Mr Tom Harley
Chief Executive Officer
SYDNEY SWANS LIMITED
PO Box 173
Paddington New South Wales 2021

16/09/2019

**Adaptive reuse of the Royal Hall of Industries (SSD-9726)
Request for Additional Information**

1 GFA PLAN - GROUND LEVEL  
1 : 400

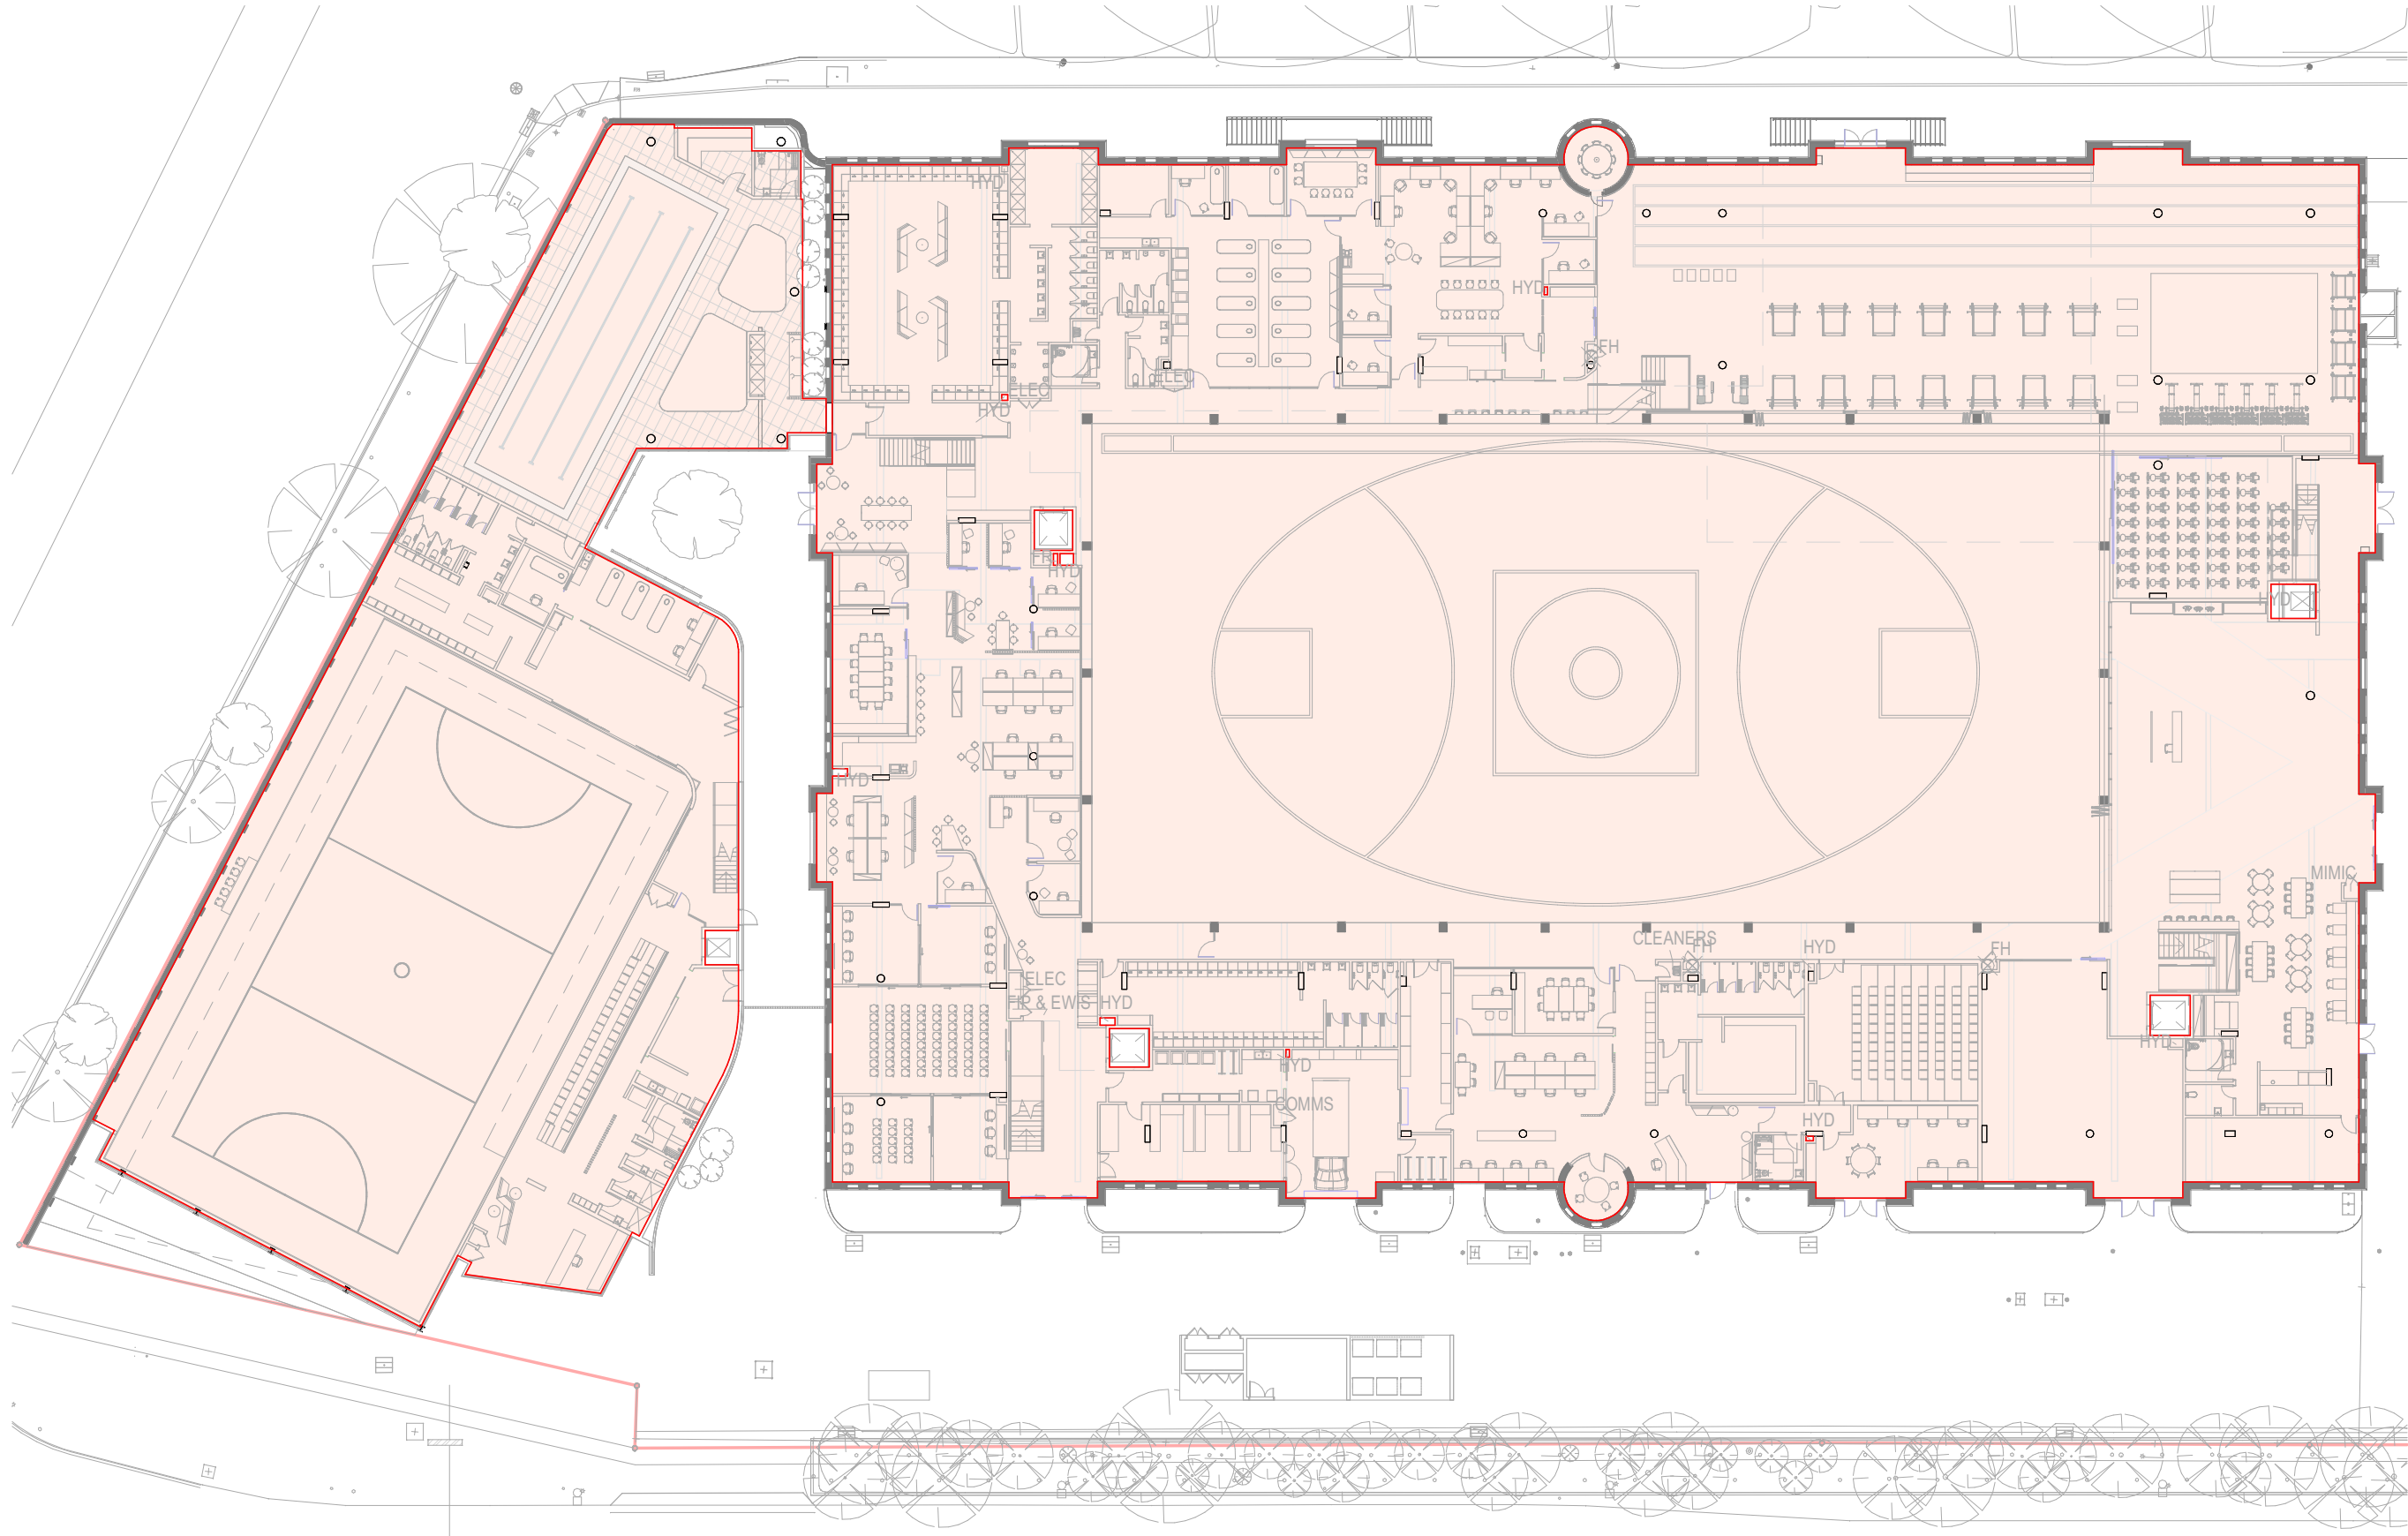
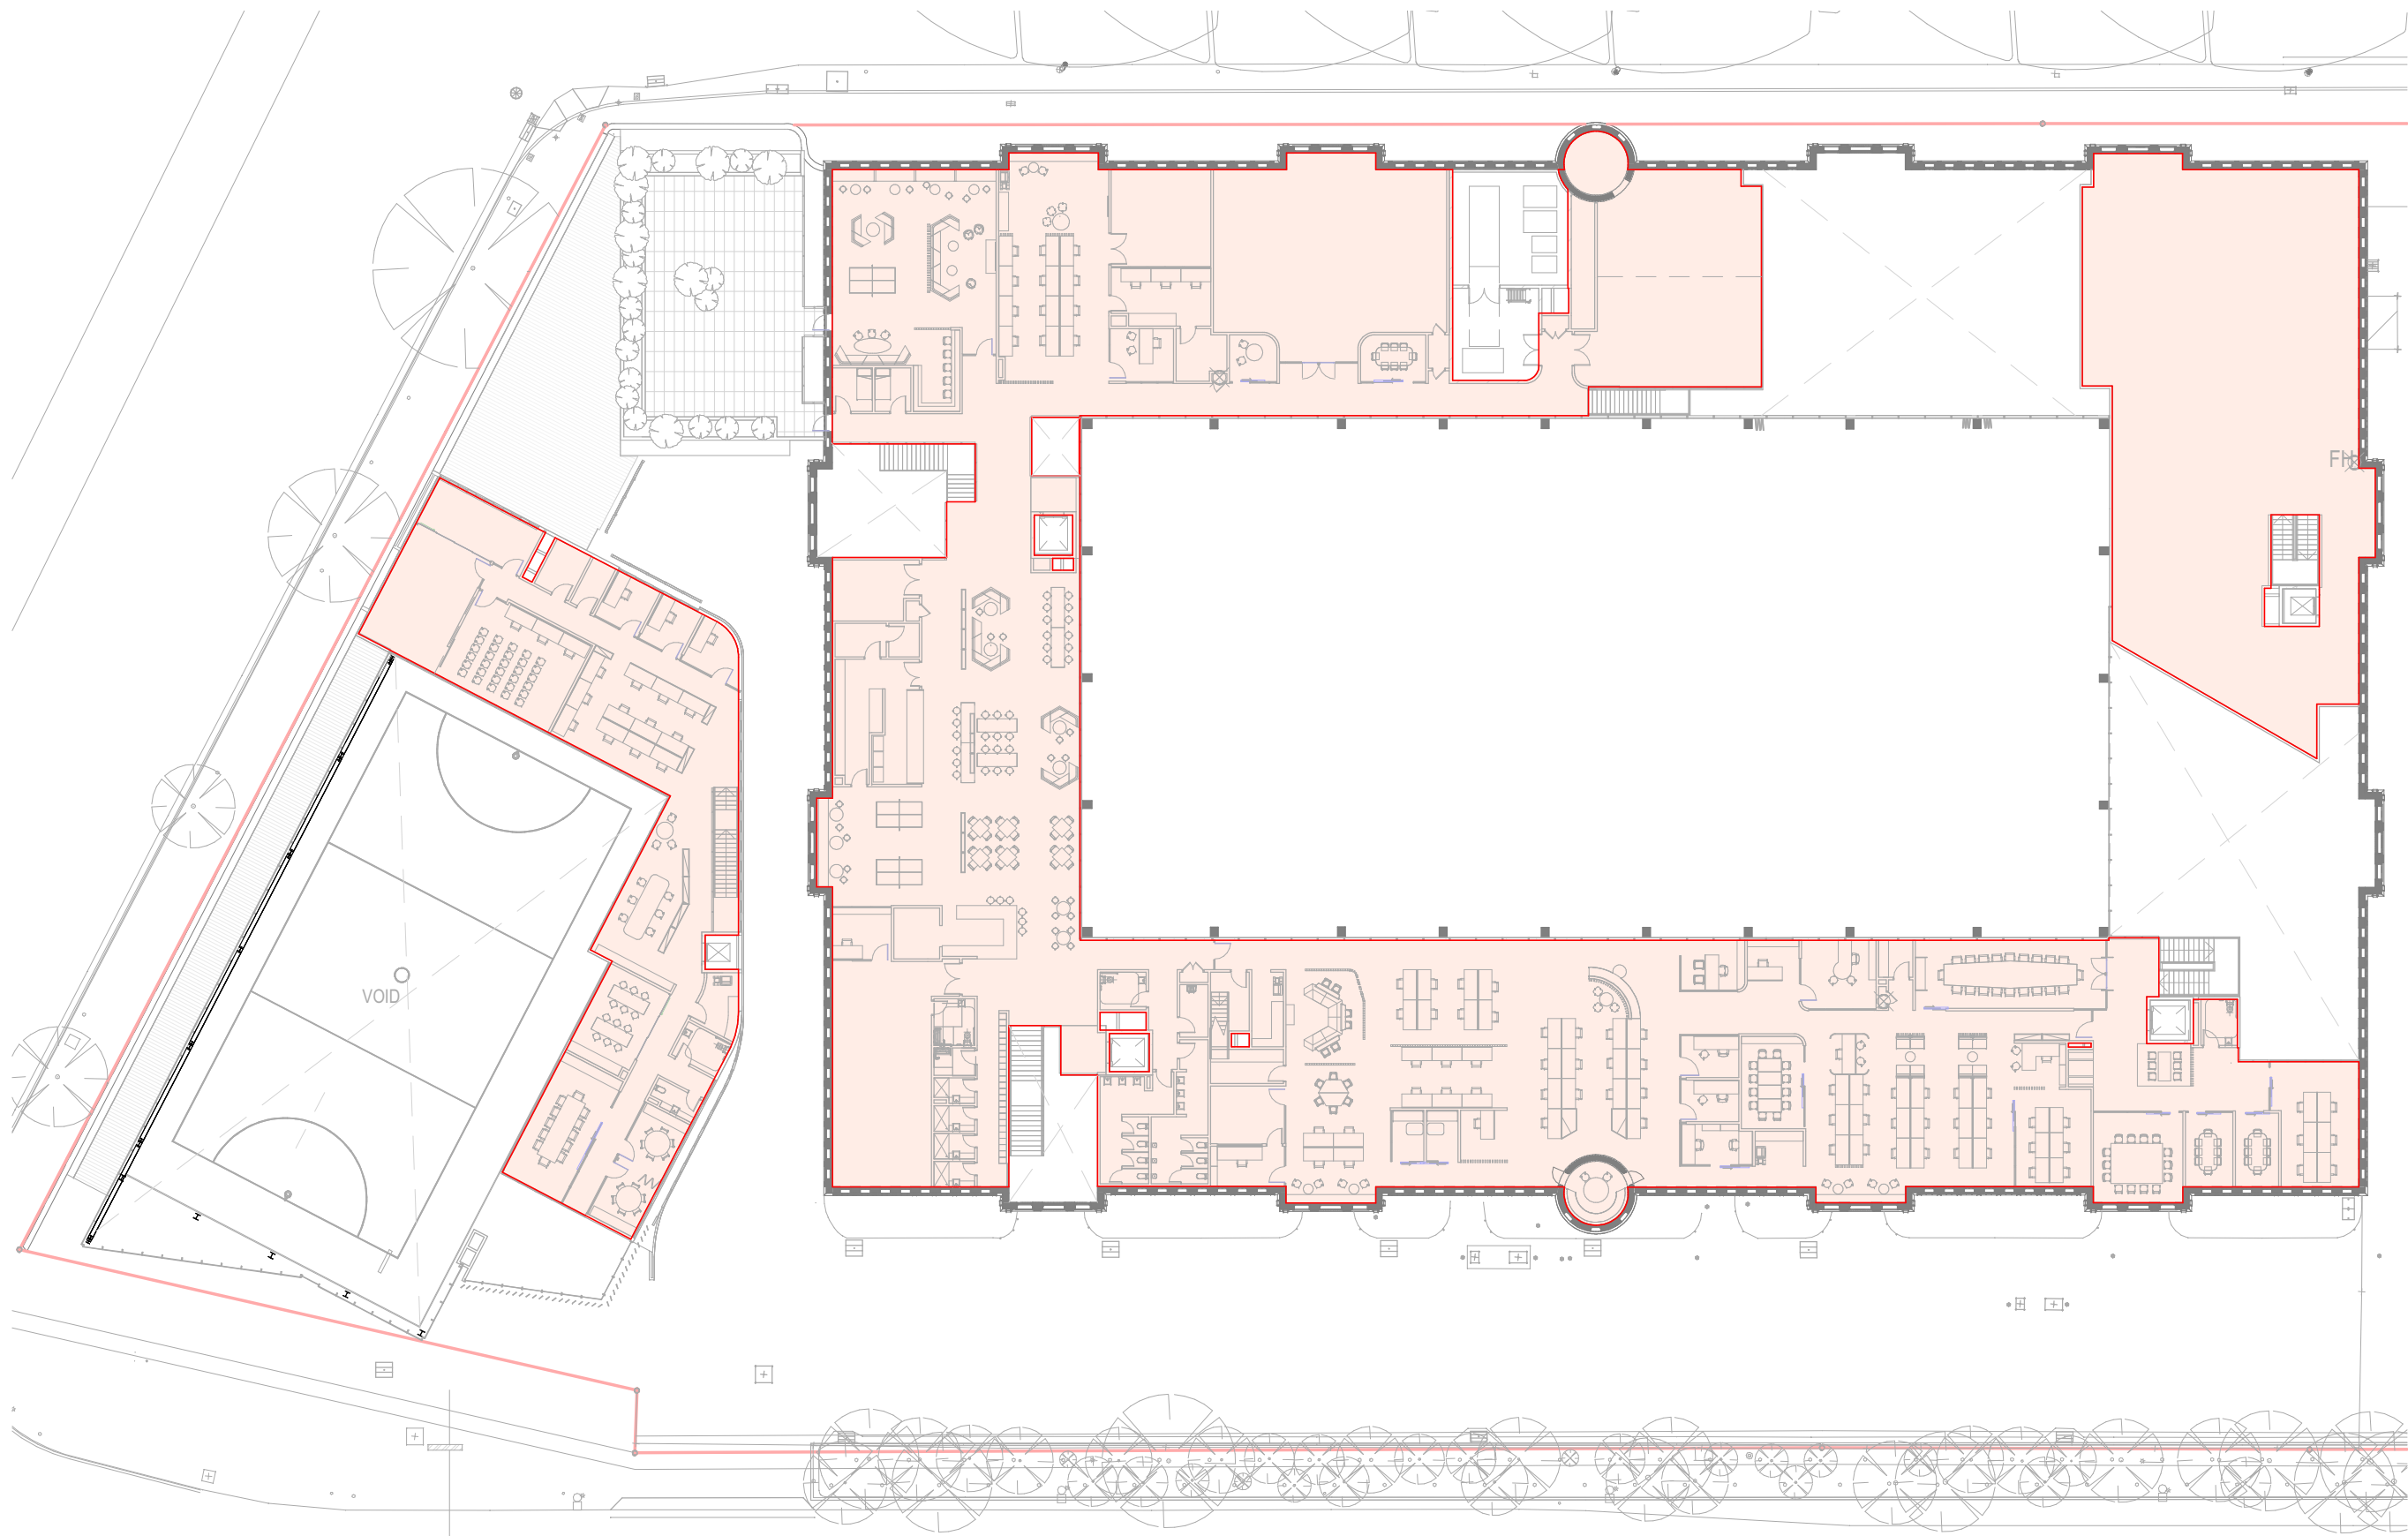
- Provide a breakdown of the proposed Gross Floor Area (GFA) for all proposed uses.
